From: [John McKeown](#)
To: [Lisa Taylor](#)
Subject: FW: Change of use of residential property to a mixed use residential/commercial premises to provide a canine hydrotherapy facility (reference no. 20/01122/COU)
Date: 16 April 2021 12:37:35

From: Jeff Brabban <[REDACTED]>
Sent: 05 November 2020 20:10
To: John McKeown <John.McKeown@bassetlaw.gov.uk>
Subject: Re: Change of use of residential property to a mixed use residential/commercial premises to provide a canine hydrotherapy facility (reference no. 20/01122/COU)

client	Mr and Mrs Freeman	drawing no.	Site Plan and Pool Enclosure	rev	A
project	Change of Use Application at "Holmelea", Top Street, East Drayton, Retford, Notts, DN22 0LG	scale	1/250 and 1/100	status	PLANNING
drawn by	JB	date drawn	02.09.2020	drawing no.	P2009.02.001

**SITE PLAN 1/250**

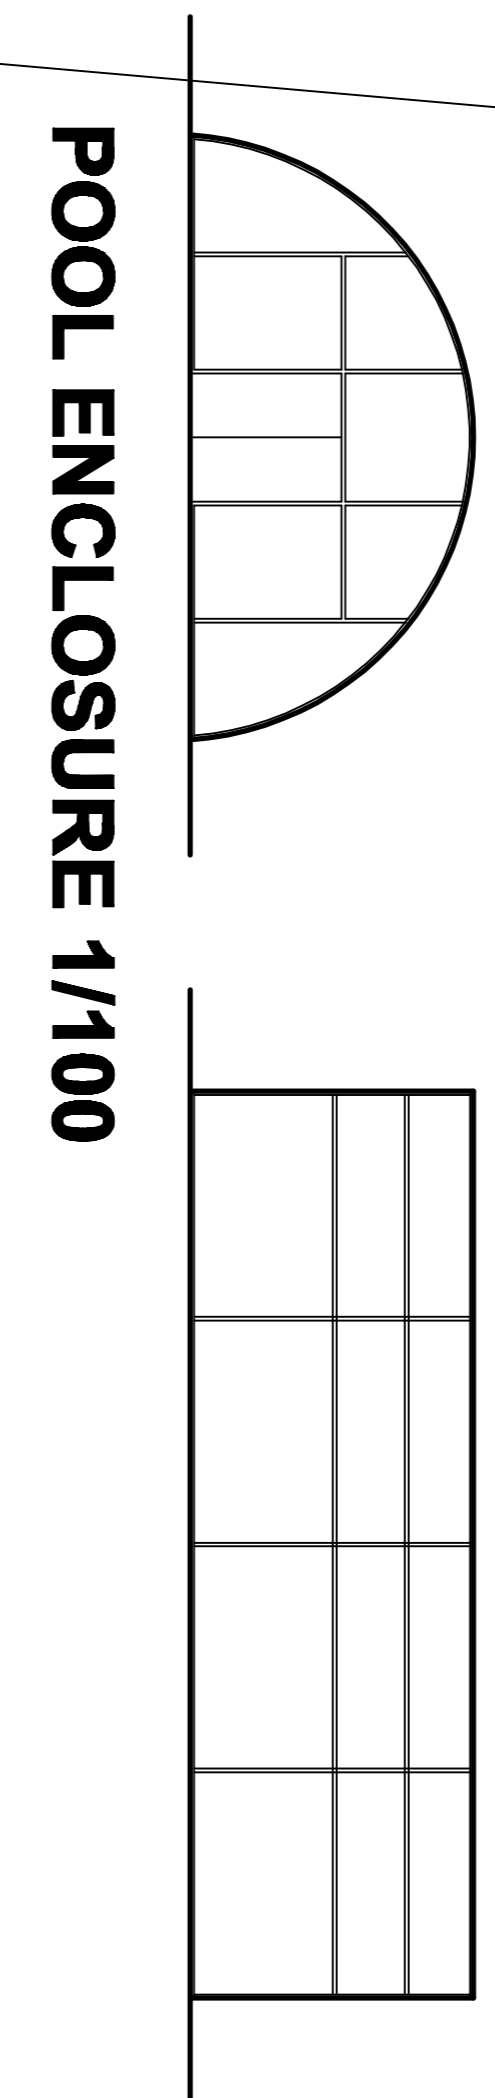
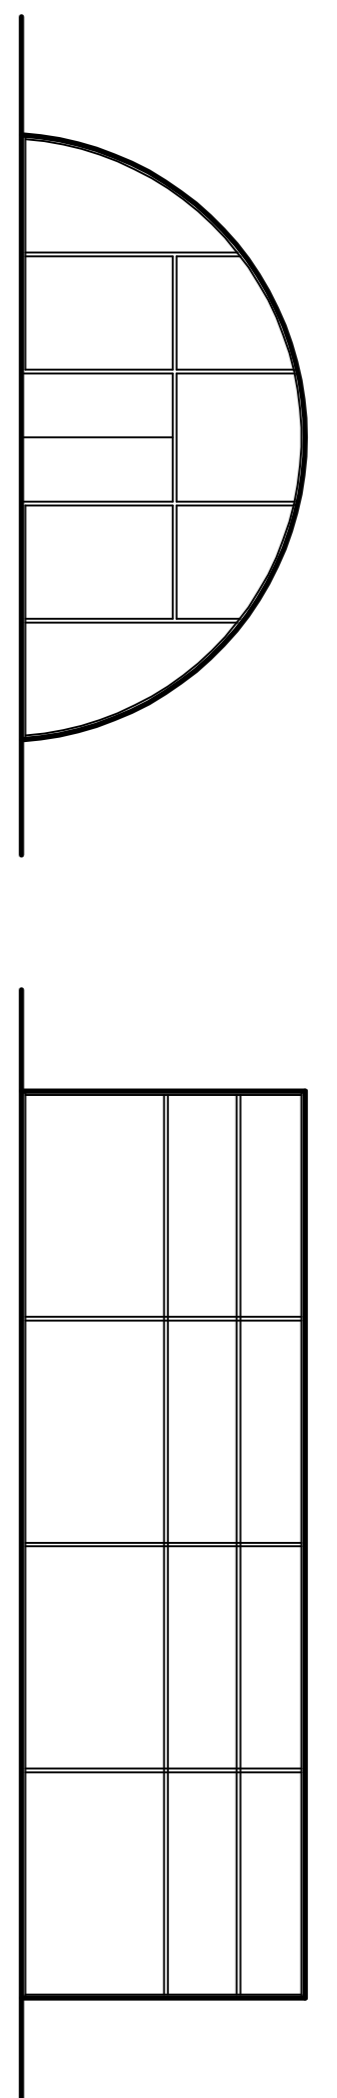
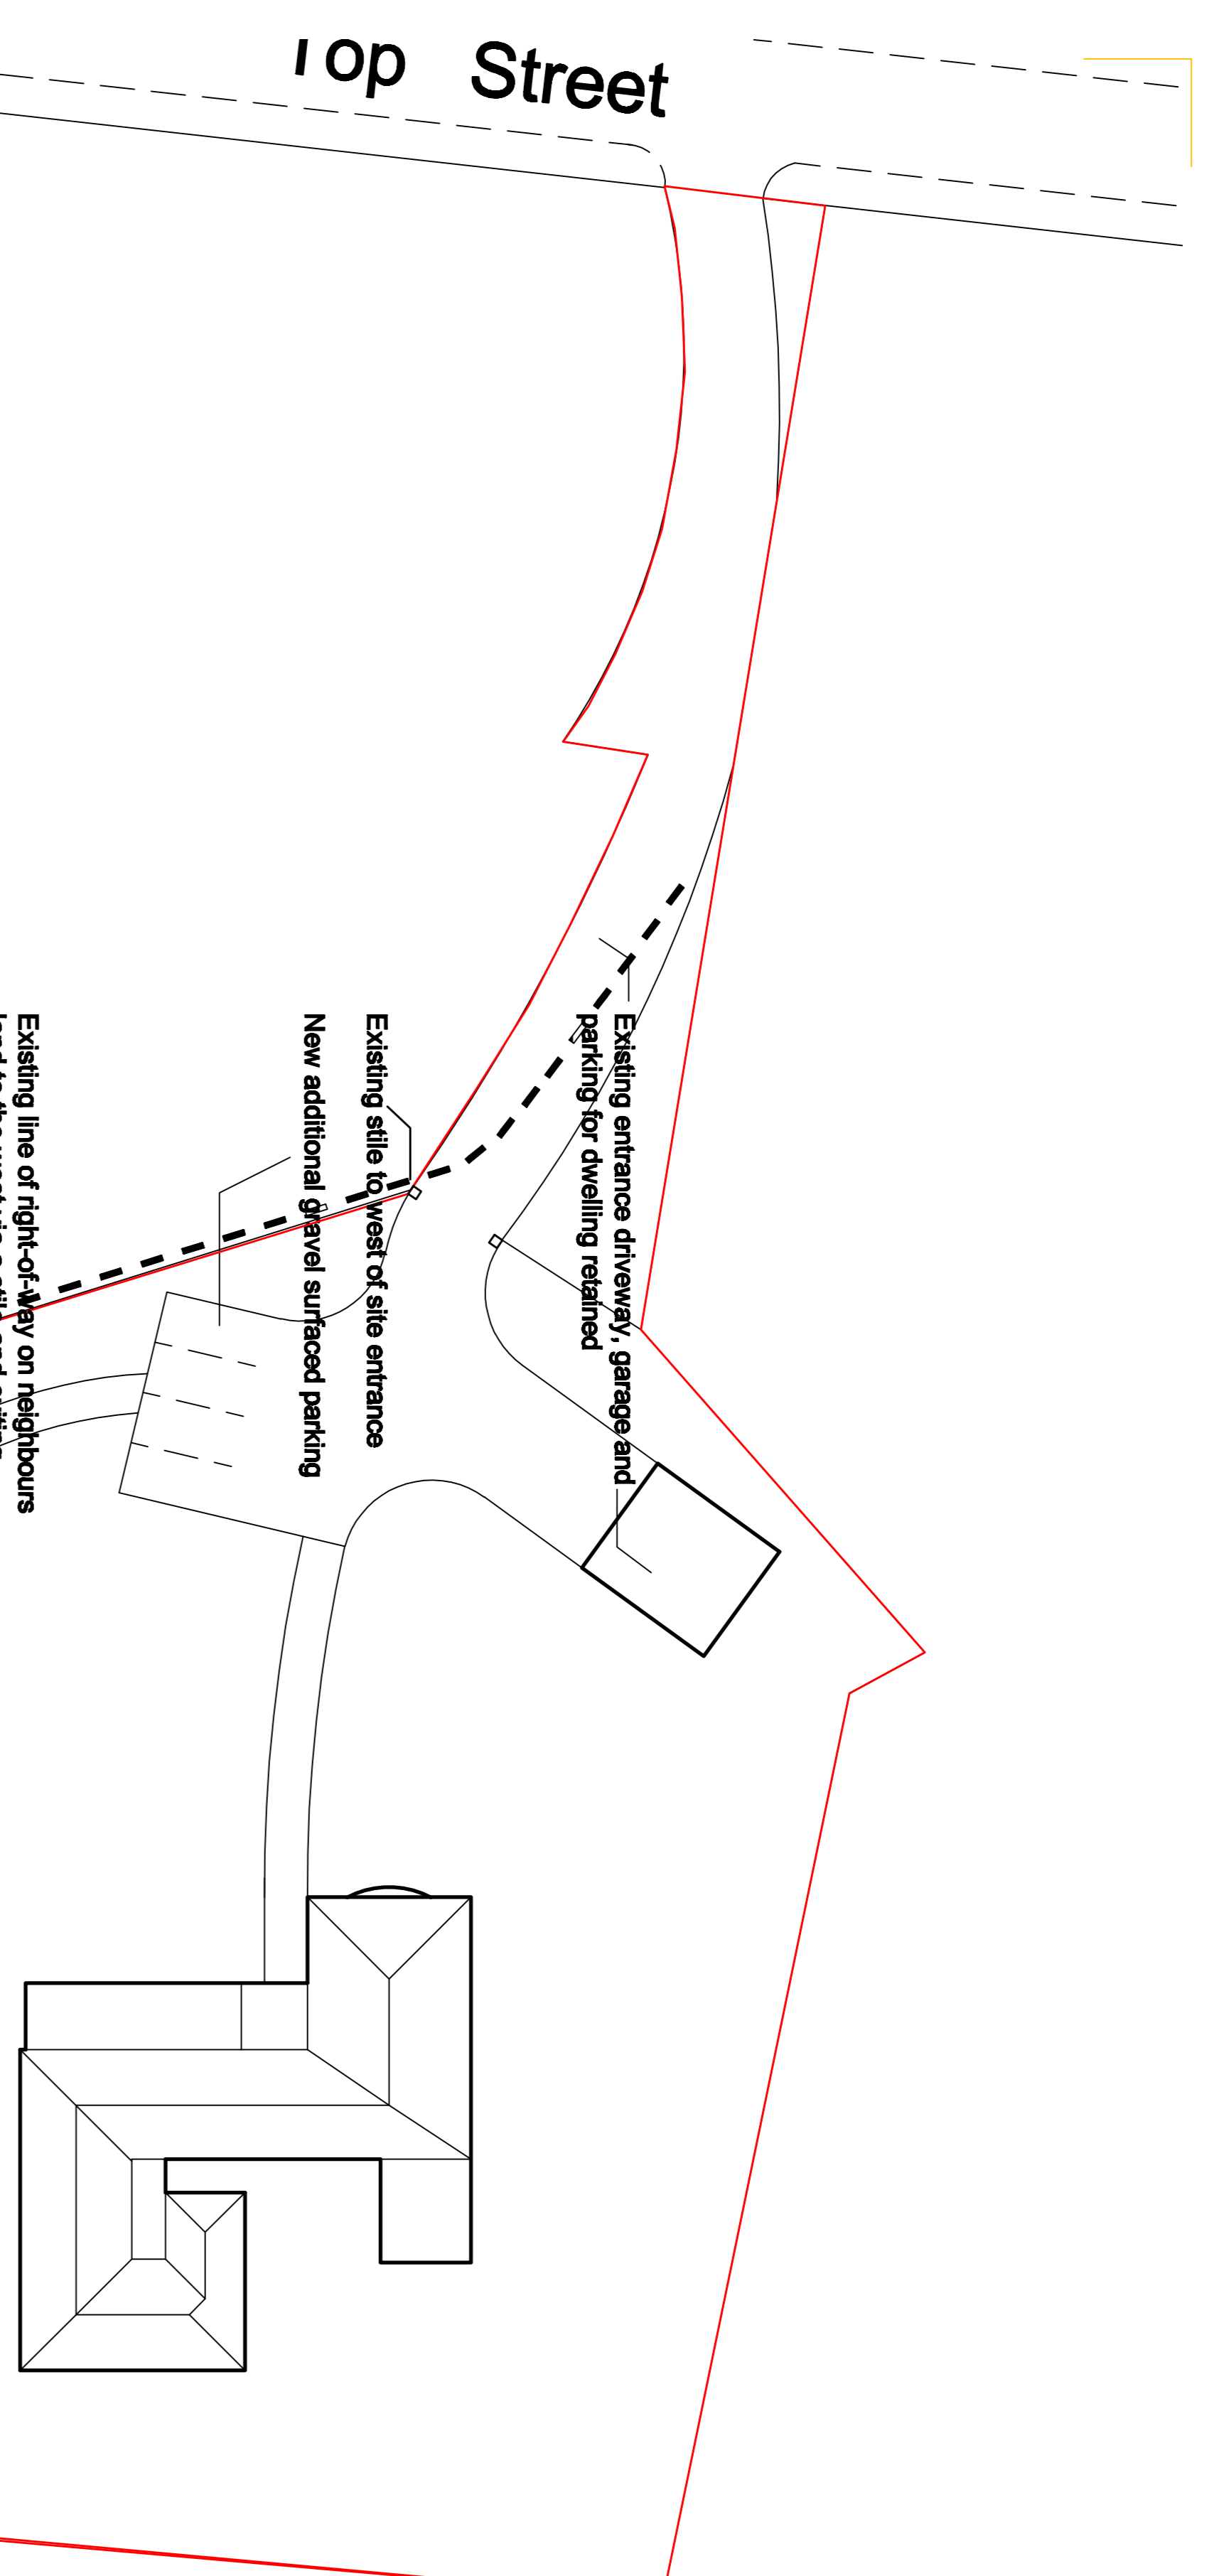
The Applicant has confirmed that the existing r-o--w is located on the adjoining neighbours land, immediately to the west of their boundary. The path is access by a stile to the right of their entrance gates. The attached revised drawing indicates the existing route of the path. I will also forward separately the Applicant's photographs to illustrate this.

The Applicant has advised that the "cabin" will be a timber clad caravan which will be used as office space and a place to make hot drinks between treatments. The lounge area will be used as a waiting area during the cold, dark winter months.
